DECISION DELEGATED TO DEVELOPMENT MANAGER

Application No: H19-0965-20 **Applicant:** Mr & Mrs C Fear
Proposal: Two Storey Extension to House
Location: Hollytree Farm Hall Gate Road Sutton St Edmund
Terminal Date: 23rd December 2020

BLOCK & LOCATION PLANS

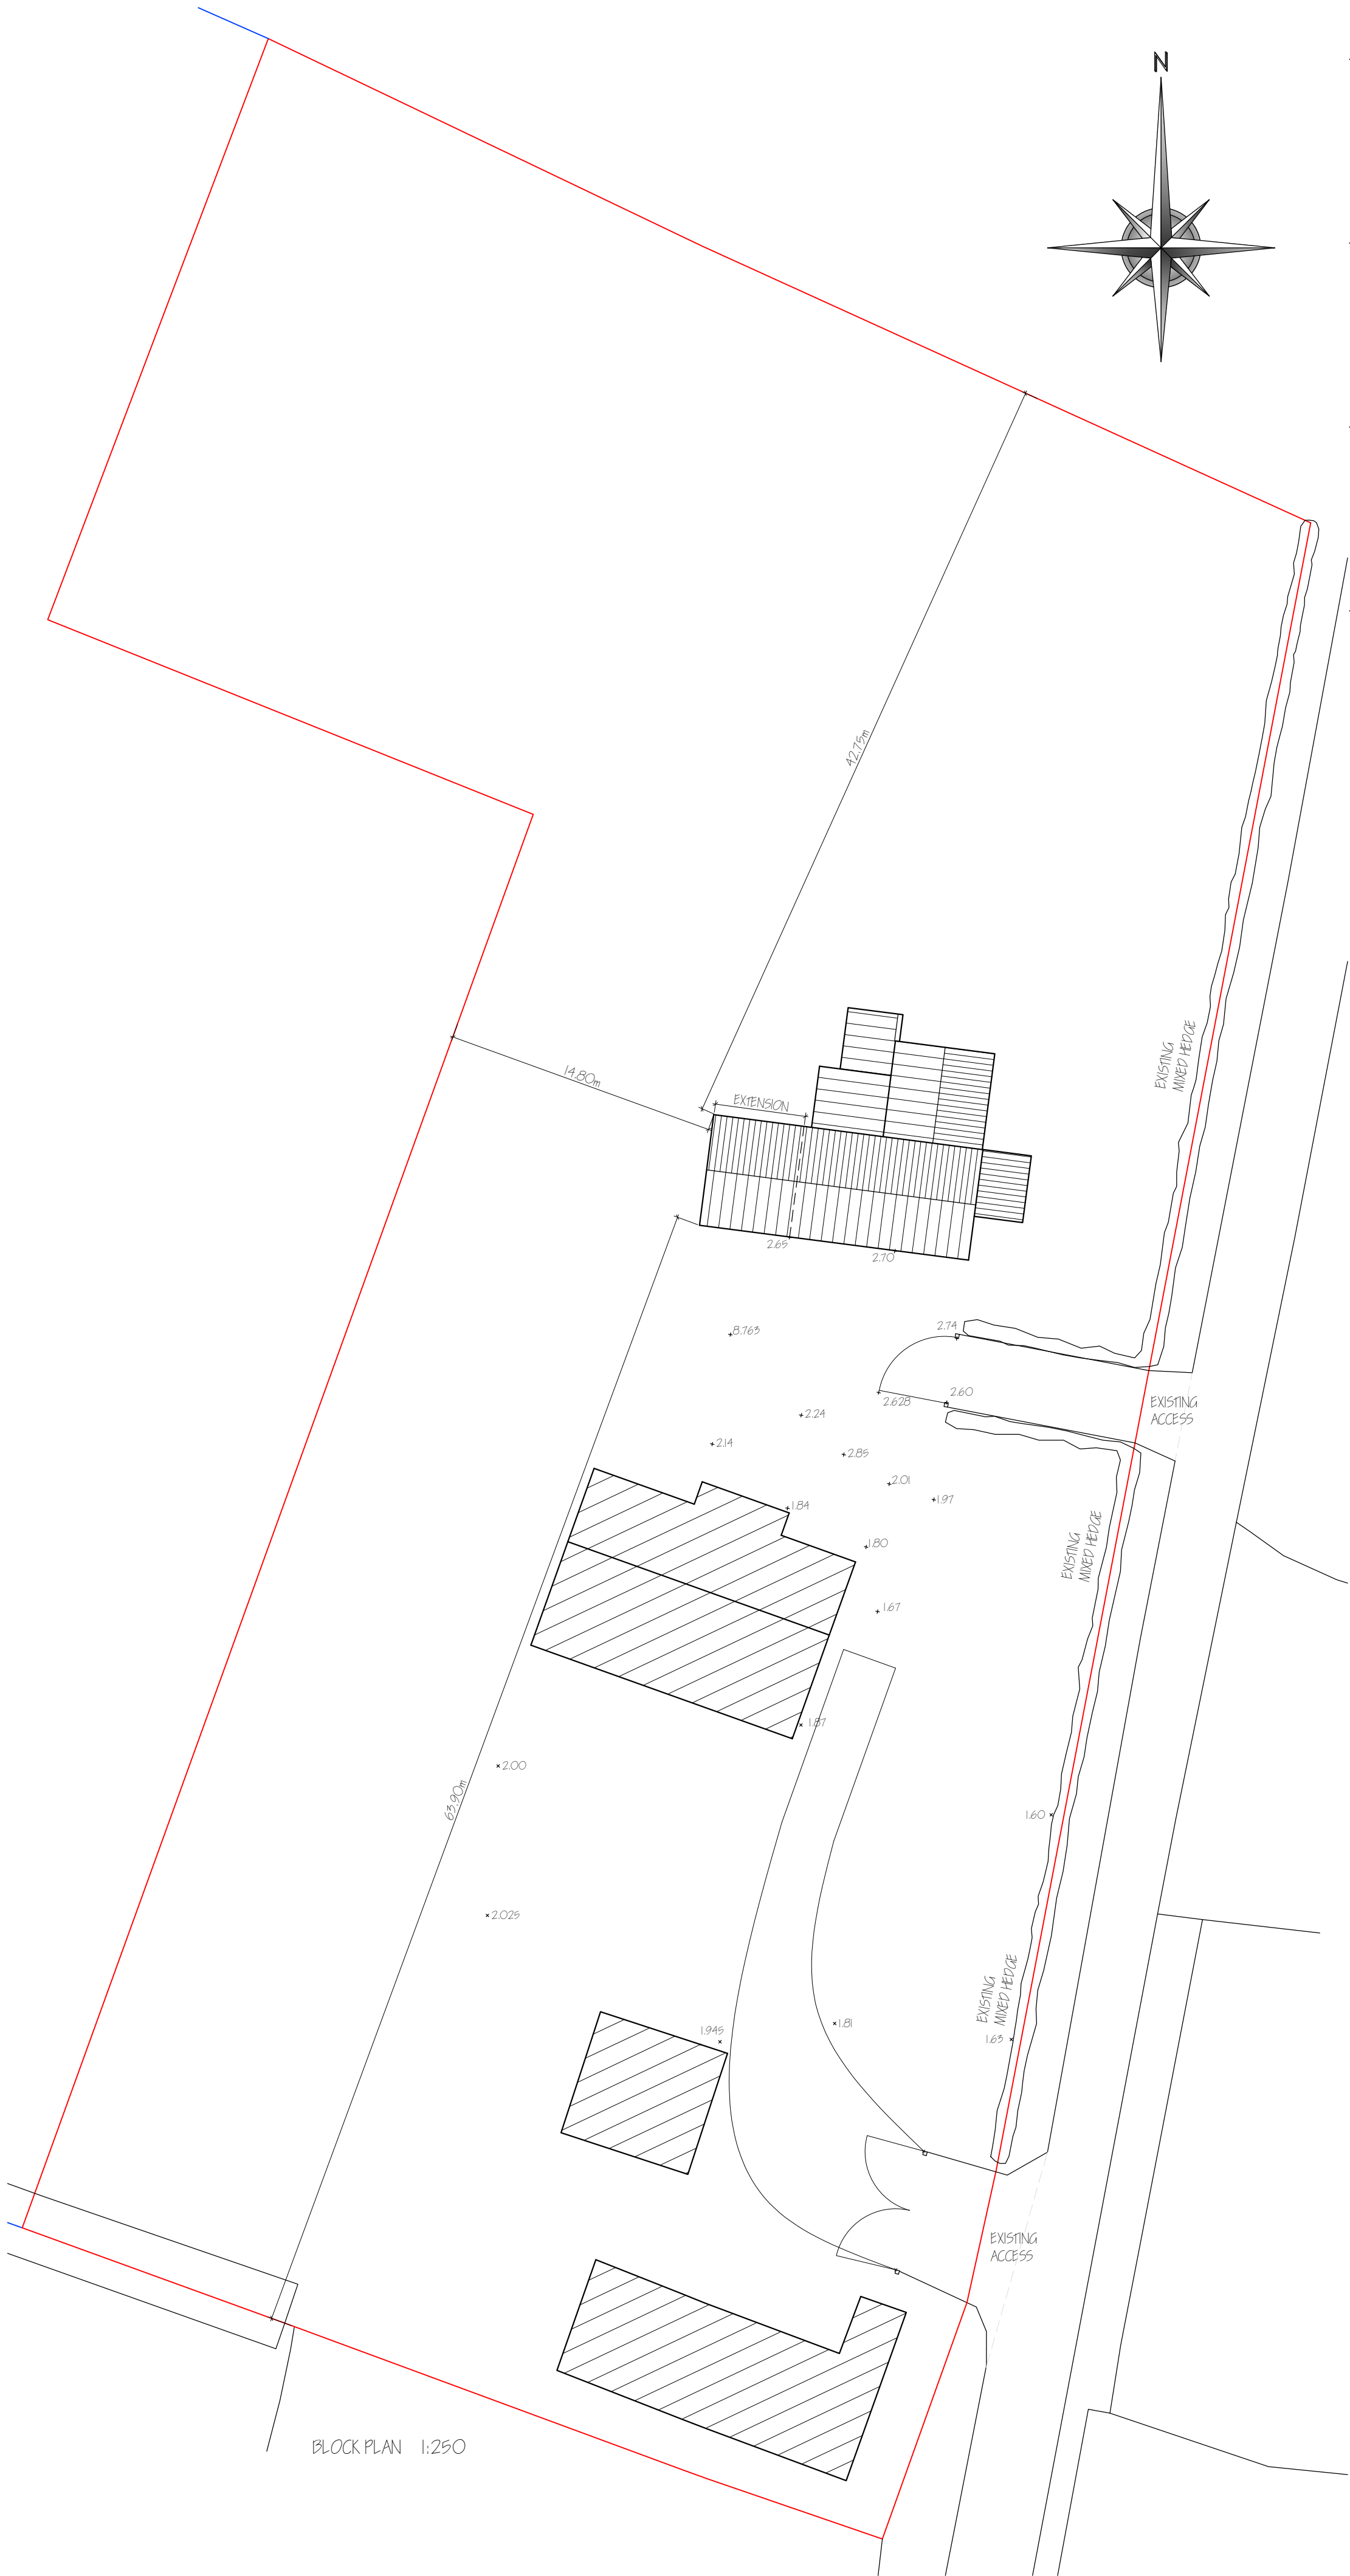
The additional bedroom proposed would increase the total number of bedrooms from 3 to 4. Three spaces for dwellings with 4 or more bedrooms should be provided within the curtilage. The drive area is visibly spacious to accommodate three cars.
